## BCA & ACCESS ASSESSMENT REPORT

**PROJECT: The Forest High School**  
**PREPARED FOR: Schools Infrastructure**

Revision 1  
Date: 22 August 2022  
Reference: 210612

DRAWING
 GENERAL ARRANGEMENT PLAN
 SHEET 3 OF 5

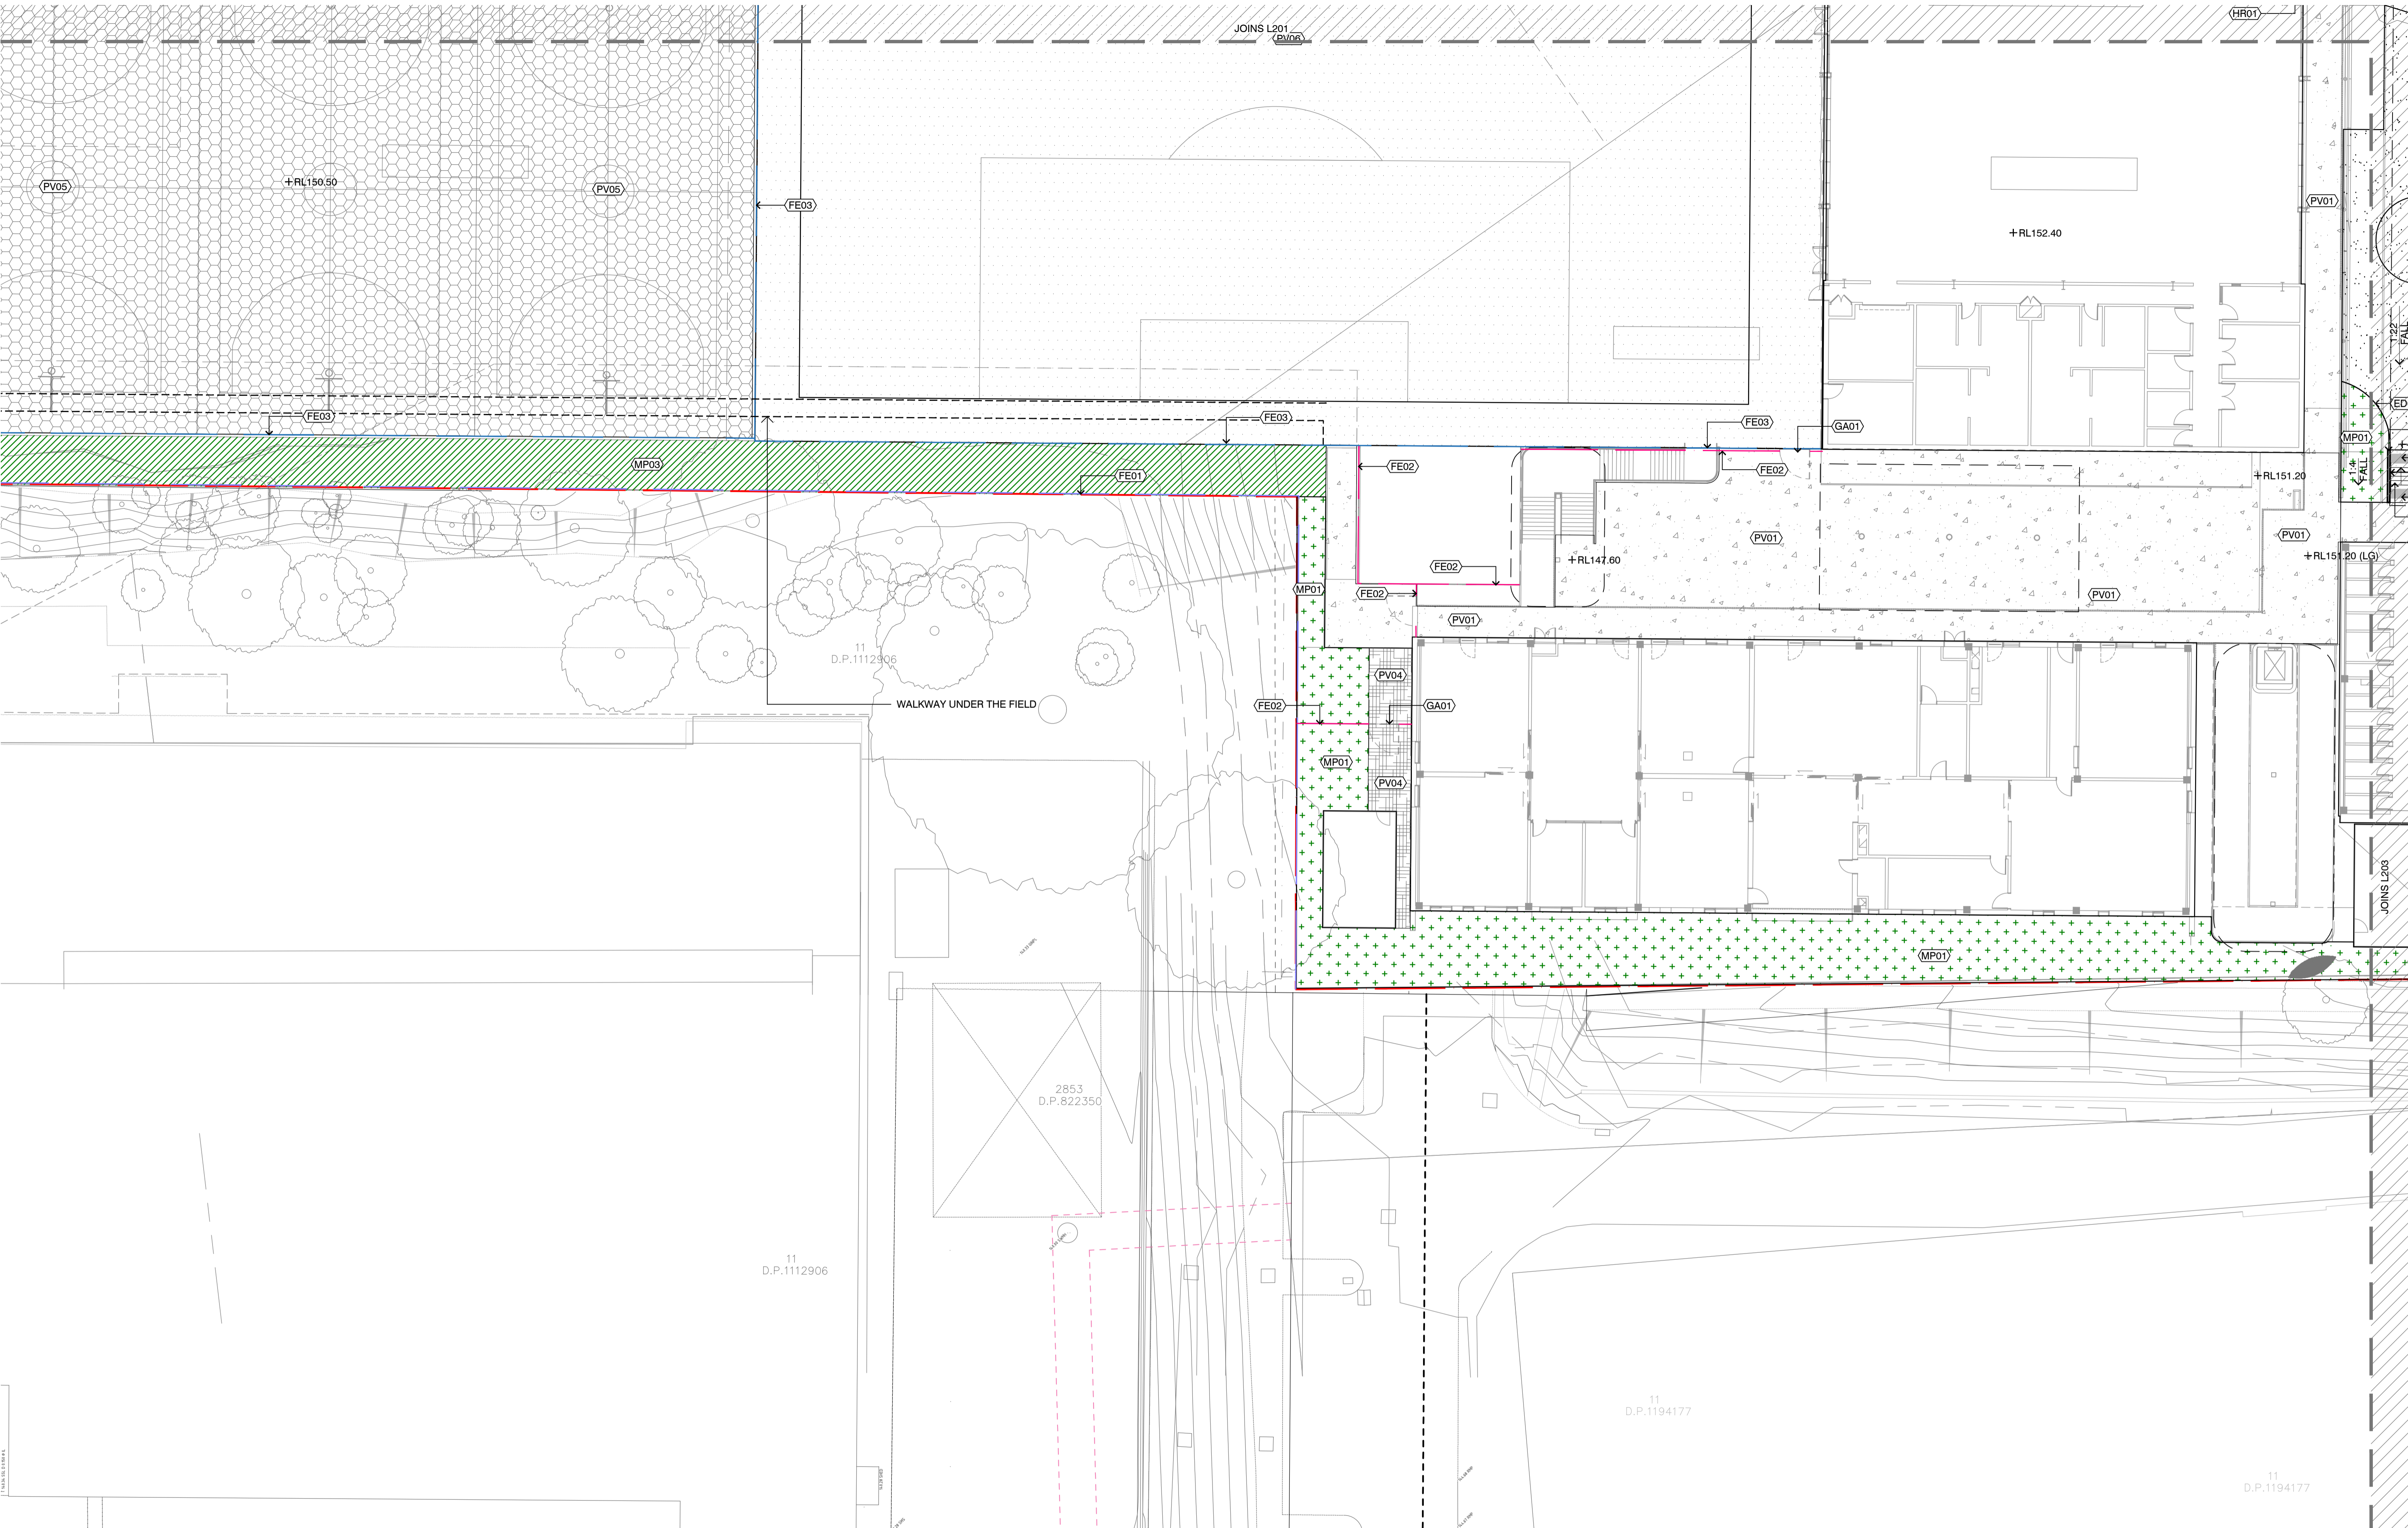
23.	<b>AS1428.1</b> <b>CI.</b> <b>11.1</b>	The proposed stairs in the central landscaped area must comply with AS 1428.1
24.	<b>AS1428.1</b> <b>CI.</b> <b>10.8</b>	The 1:20 ramps in the Norther west corner near Block G shown on the landscaping plans must have min. 1500 x 1500m landings;
